KIRKLEES METROPOLITAN COUNCIL INVESTMENT & REGENERATION SERVICE

DELEGATED DECISION TO DETERMINE APPLICATIONS FOR CONSENT, AGREEMENT OR APPROVAL REQUIRED BY CONDITION

Reference No:	2022/44/92957/W
Site Address:	Former Hoyle Ing Dyeworks, Hoyle Ing, Linthwaite, Huddersfield, HD7 5QS
Description:	Discharge of conditions 3 (external facing materials), 4 (roofing materials), 5 (boundary treatment), 7 (amended elevations and sections), 8 (demolition), 11 (BEMP), 13 (noise), 17 (electric vehicle charging), 18 (CEMP), 19 (landscape) and 29 (waste collection) of previous permission 2021/94664 for demolition of existing building and development of the former dyeworks comprising 9 apartments, 4 bungalows and 2 maisonettes (within a Conservation Area)
Recommending Officer:	Ellie Worth

Officer report

Proposed EVCP Locations

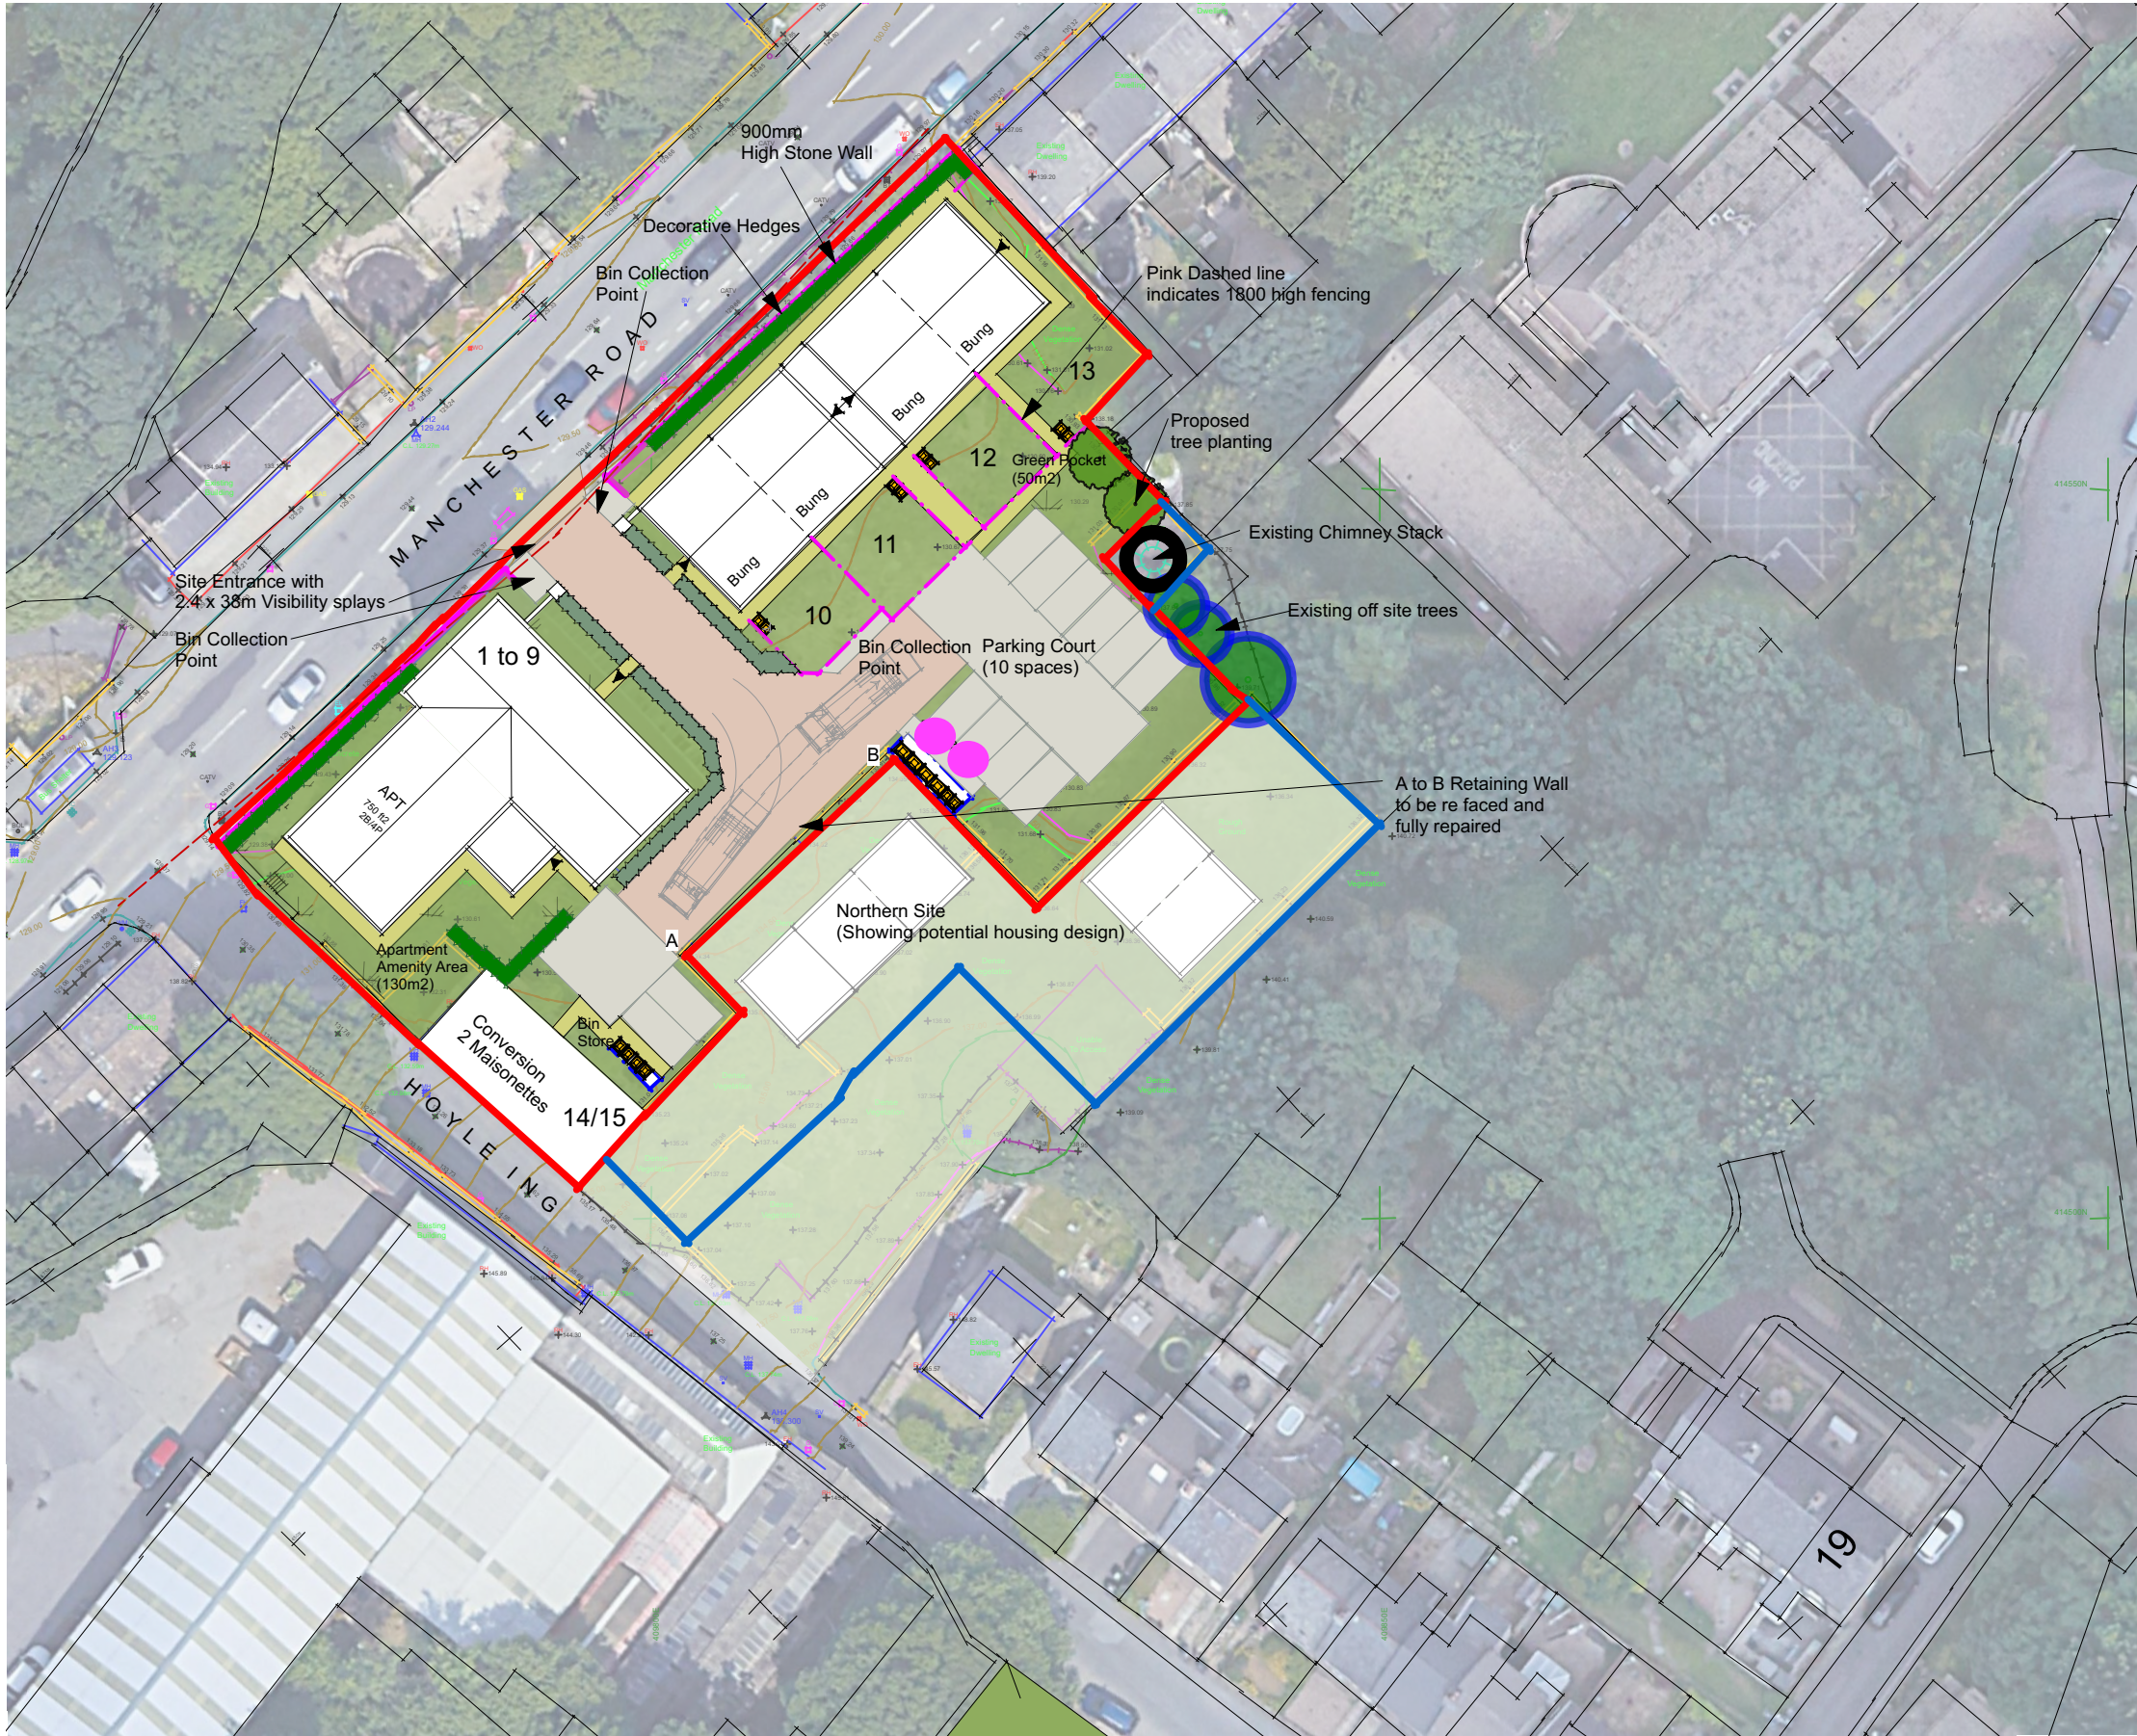
The plan illustrates the location of four Electric Vehicle Charging points within the site boundary and sets out that there will be twelve parking spaces overall, suggesting the spaces are unallocated. This is due to the residents being unable to drive and therefore the spaces will be unallocated and for staff and visitors.

The submitted specifications for the charging points meet the power requirements of condition 17.

Given the above assessment, the proposed four EVCPs are acceptable and accord with condition 17.

Figure 7: Internal layout of apartments

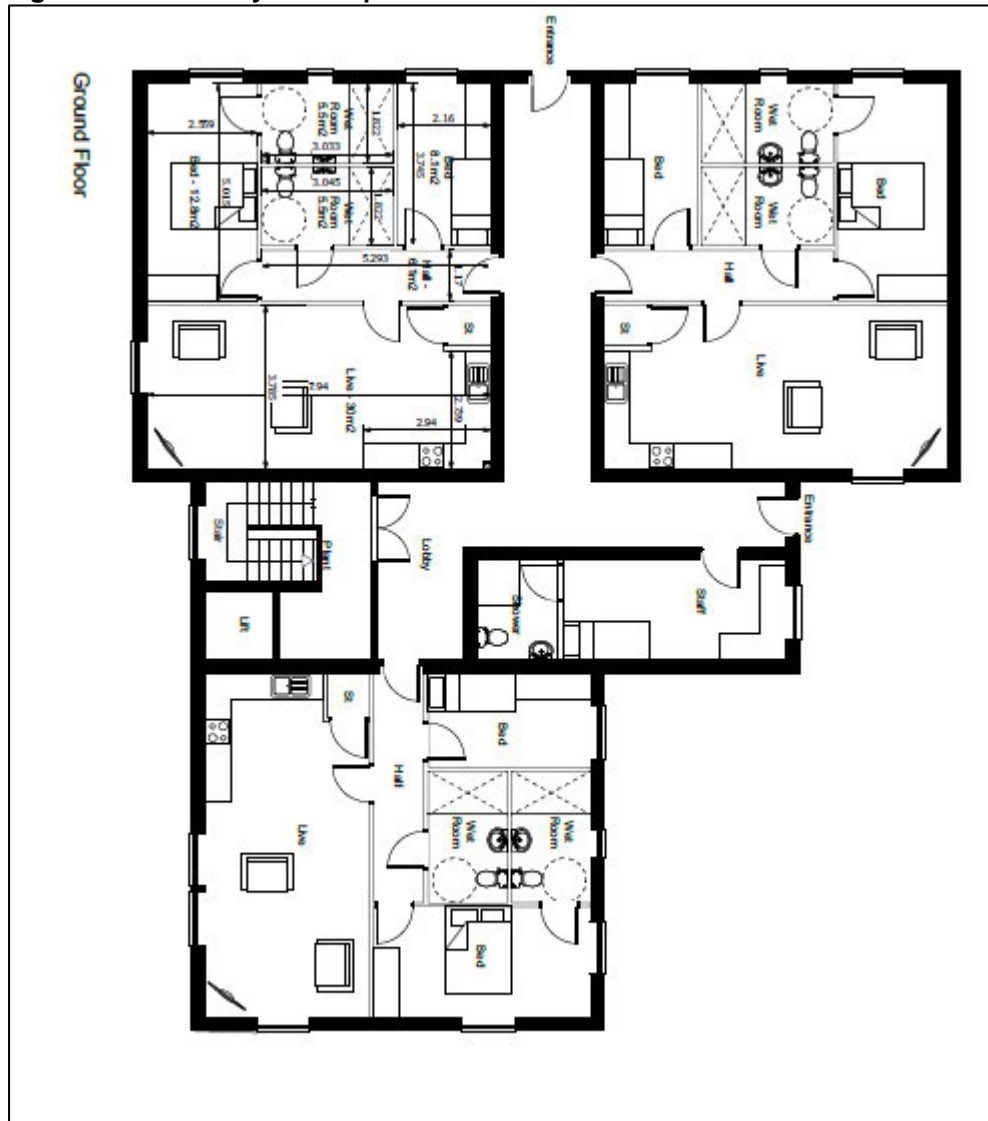
Figure 7 shows the Internal layout of the apartments, figure 8 shows the internal layout of the bungalows showing there are no bungalow bedroom windows facing Manchester Road, and figure 9 shows the internal layout of the maisonettes. Based upon distance attenuation along with a 3dB correction for reflection, figure 10 specifies the required glazing for the apartments and figure 11 specifies the required glazing for the maisonettes. Table 4 indicates that with windows closed, the internal requirements of BS8233 would be met for all parts of the development. However, in order to achieve the BS 8233 guideline values and prevent disturbance, particularly sleep disturbance at night, the assessment shows that it will be necessary to keep habitable room windows closed. Para 4.22 states an alternative means of providing both background and cooling ventilation will be required in all habitable rooms which is typically achieved through the provision of whole-house passive input ventilation (PIV) or mechanical ventilation, either as whole-house systems (MVHR) or as through-wall solutions in individual rooms.
